TWEED VALLEY HOSPITAL NSW

ARCHITECTURAL AND URBAN DESIGN RESPONSE TO
EIS / SSD STAGE 2 APPLICATION SUBMISSIONS

26 FEBRUARY 2020

1 ELEVATION 1 (NORTH)
Elevation 1 : 200

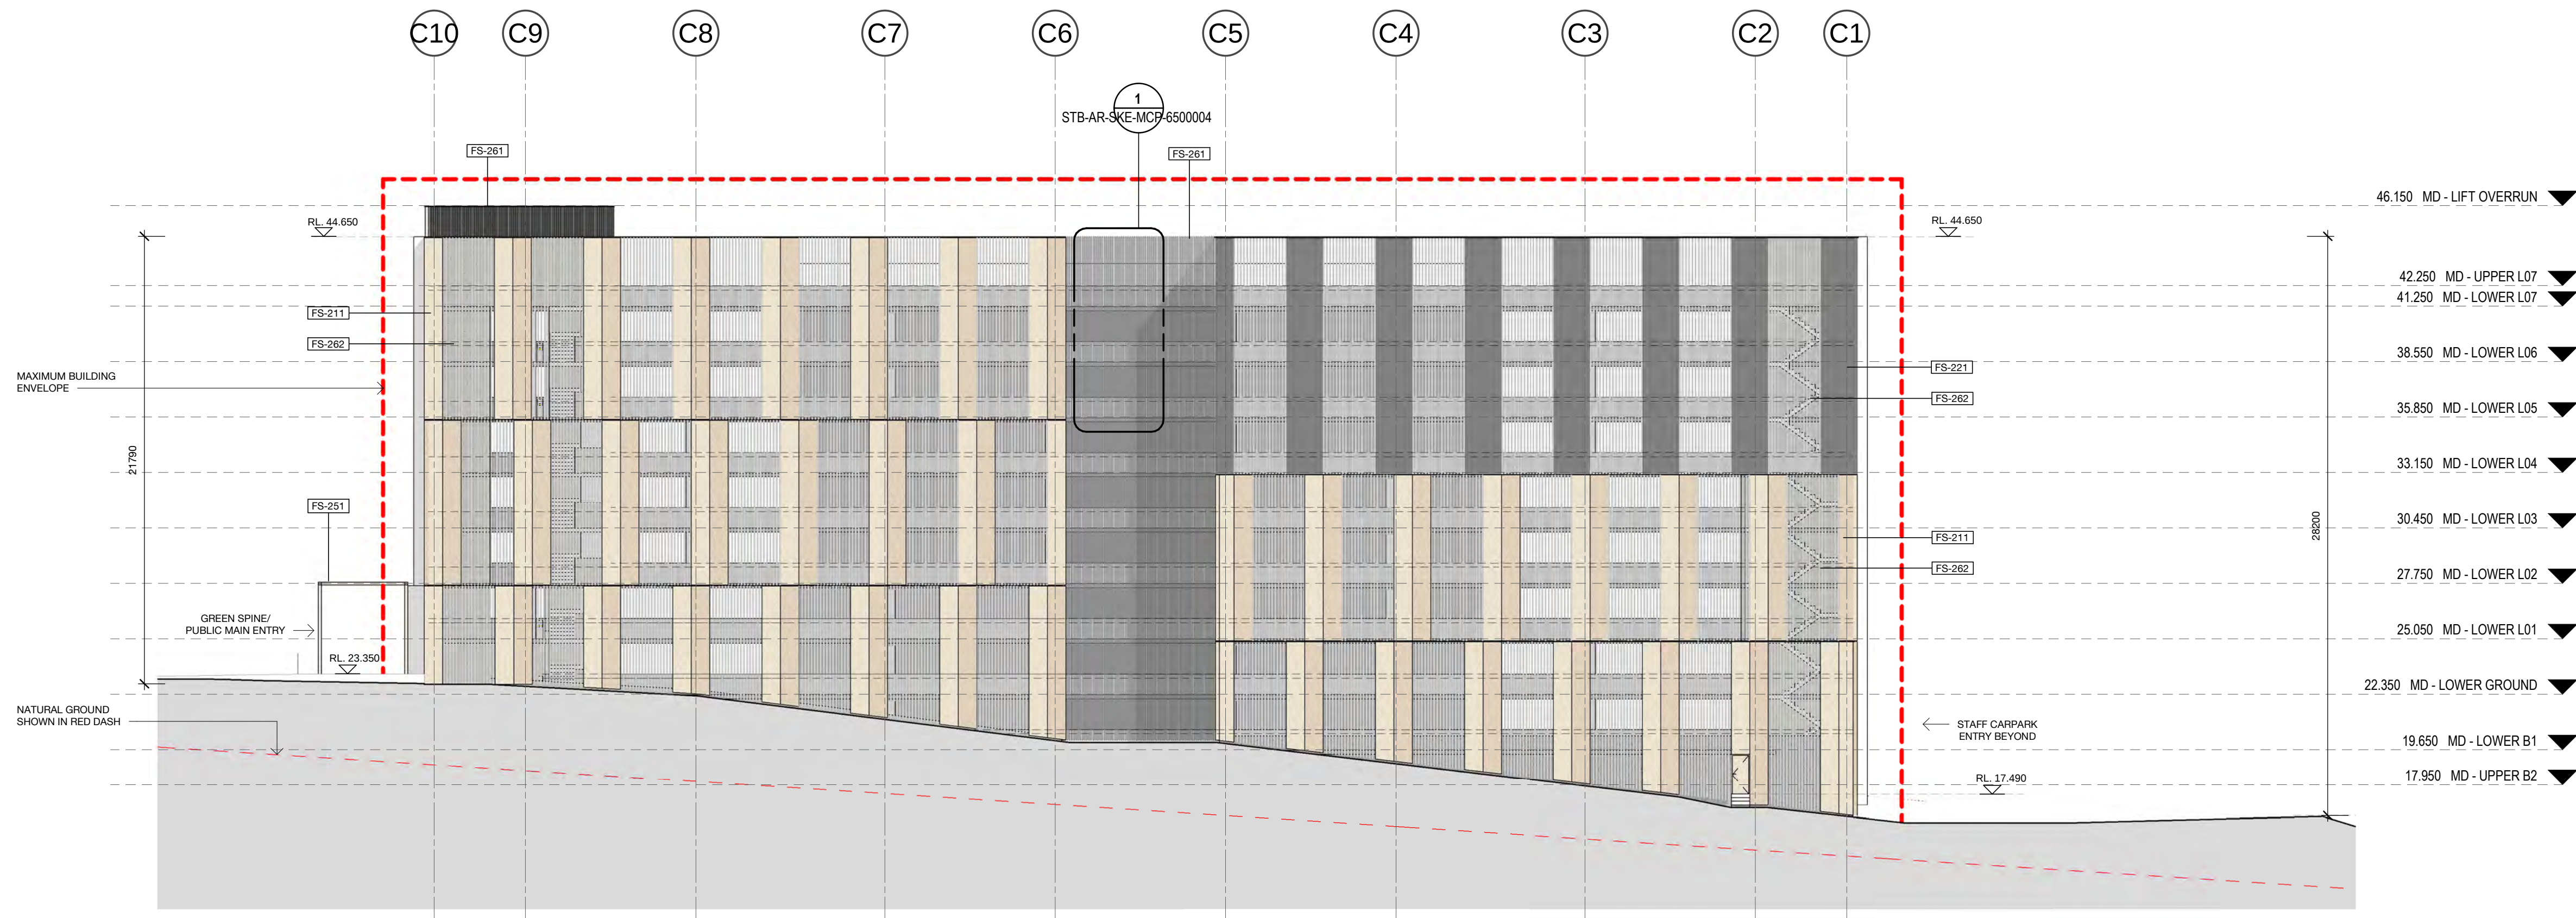
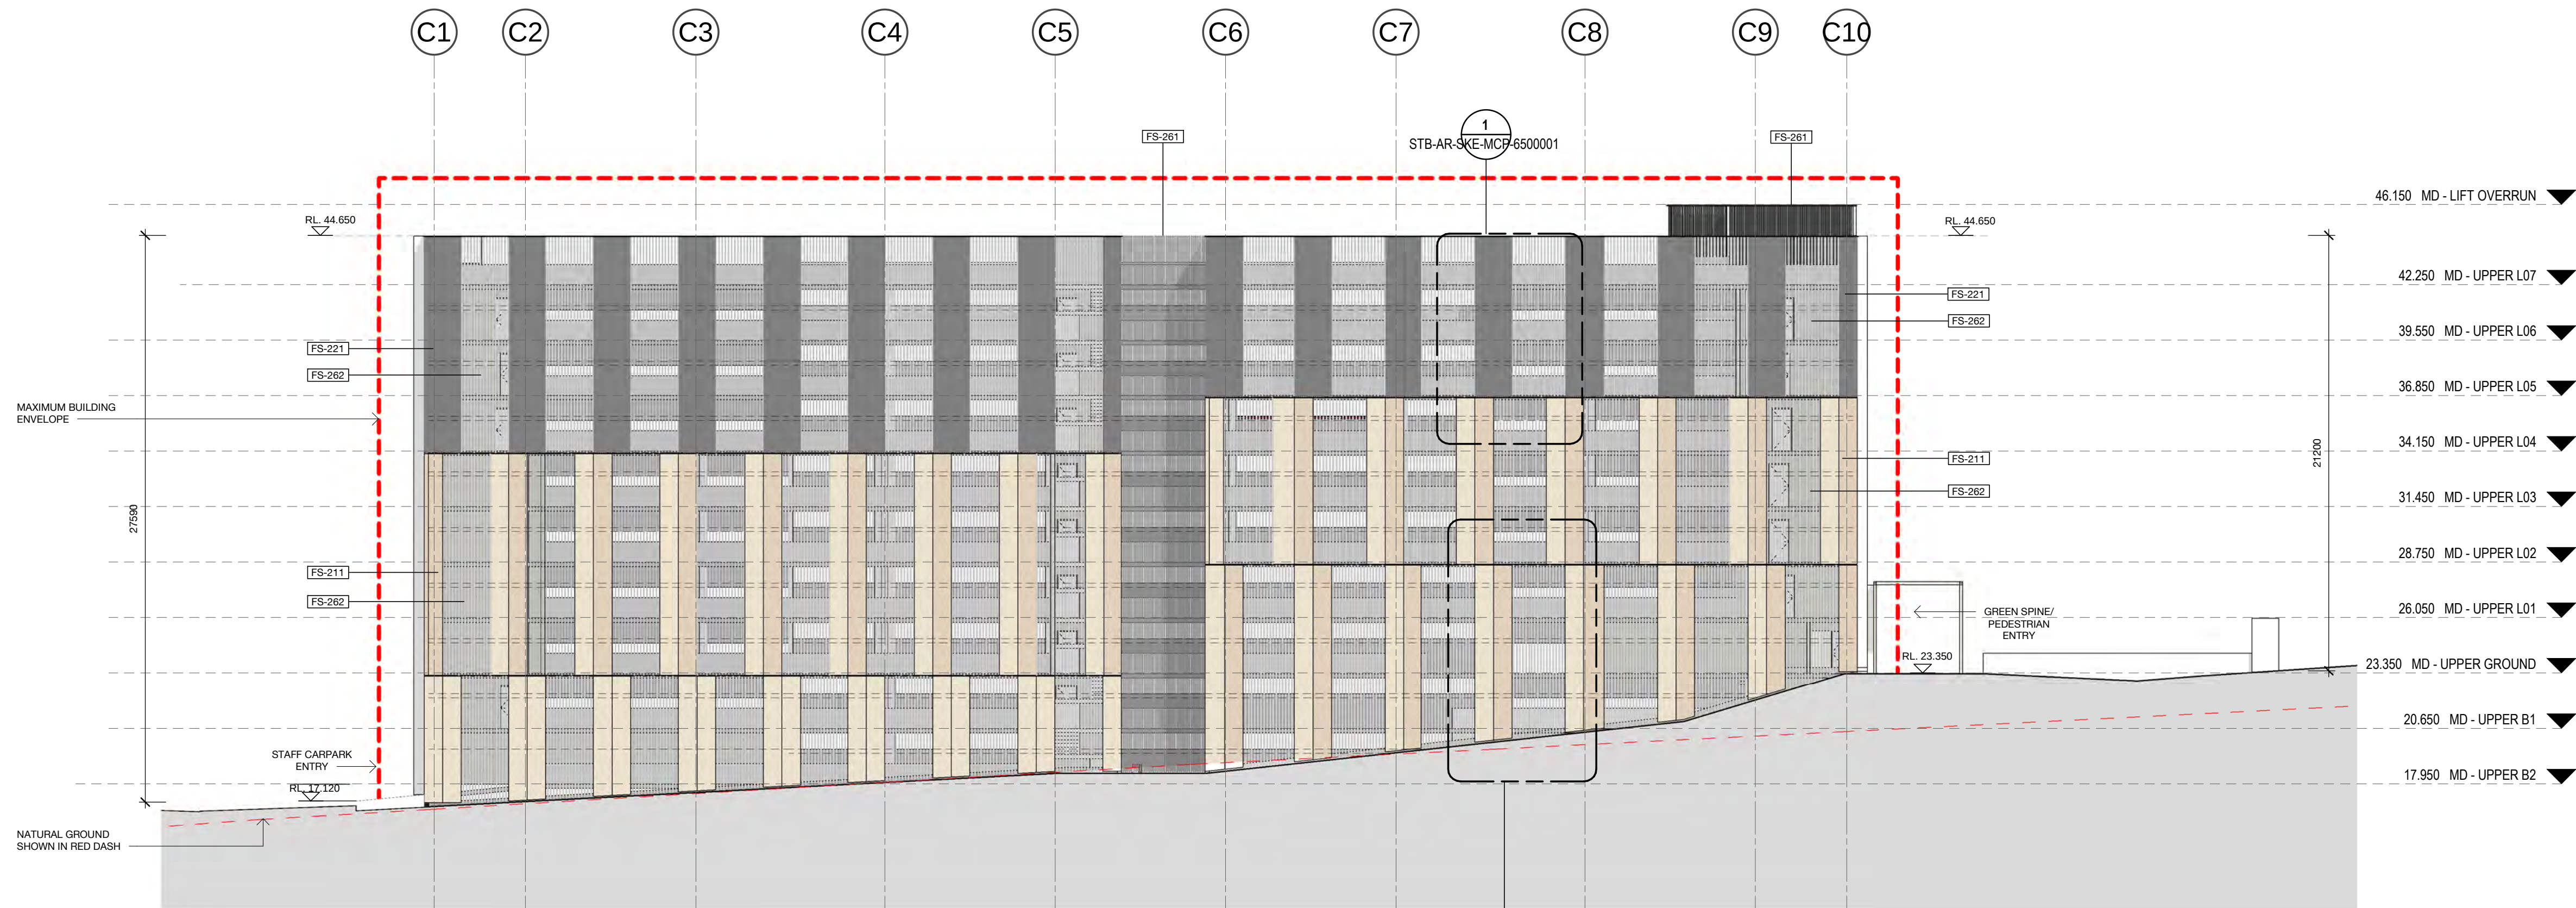
“The main element of the modification that Council wants the Department to further investigate is the introduction of the 10 storey multi-deck carpark on the western side of the development site. This will be the first element of the site for anyone visiting the Hospital from the main Tweed Coast Road and M1 Highway. To date the application has not demonstrated a western photomontage of the multi-deck carparking area” ...

...” or suggested sufficient mitigation measures to soften the impact of this structure. The multi-deck carpark appears to represent a solution for onsite parking however it could be better incorporated into the site” ...

“with softer design elements (green walls),”...

“an air bridge connecting to the main hospital, and further site consideration for additional covered awnings throughout the site”.

The application has provided more distant western photomontages of the development site to give a clear demonstration of the visual impact of the development including the multi-deck carpark from viewpoints identified in the submitted Visual Impact Assessment. The Visual Impact Assessment September 2019, located in the EIS Appendix J, conducted by Urbaine includes three viewpoints taken from key locations from the western approach. Viewpoint No.15 taken from the location of the junction of Cudgen Road and Tweed Coast Road (Visual Impact Assessment Scale of 6), Viewpoint 18 at the driveway of 740 Cudgen Road (Visual impact assessment scale of 3) and Viewpoint 19 taken from the boundary fence of 748 Cudgen Road (Visual Impact Assessment scale of 6) . The visual impact assessment scale No.6 is classified in the lower range of medium negative impact on the pre-existing visual quality of the view, No.3 is classified as a minor negative impact on the pre-existing visual quality of the view.

The size of the multi-deck carpark is in direct response to the 2023/24 demand study which outlined the numbers of car spaces across the TVH development site. The inclusion of a multi-deck carpark of this size was needed to ensure safe, secure and accessible means to access the main hospital building and allow for future development zones to the west. The location of the multi-deck carpark to the western side of the main hospital building is:

Irrigated in-ground planting to the screened sections of the carpark has been included in the design to reinforce the green spine concept which denotes the main east west pedestrian circulation network. This strategy has been employed to ensure the multi-deck carpark is integrated into the landscape creating a softer natural interface with the public and staff at low levels.

The circulation path from the multi-deck to the hospital is covered and level and activated through high quality public space negating the need for an air bridge connecting ground level of the main hospital building to the multi-deck.
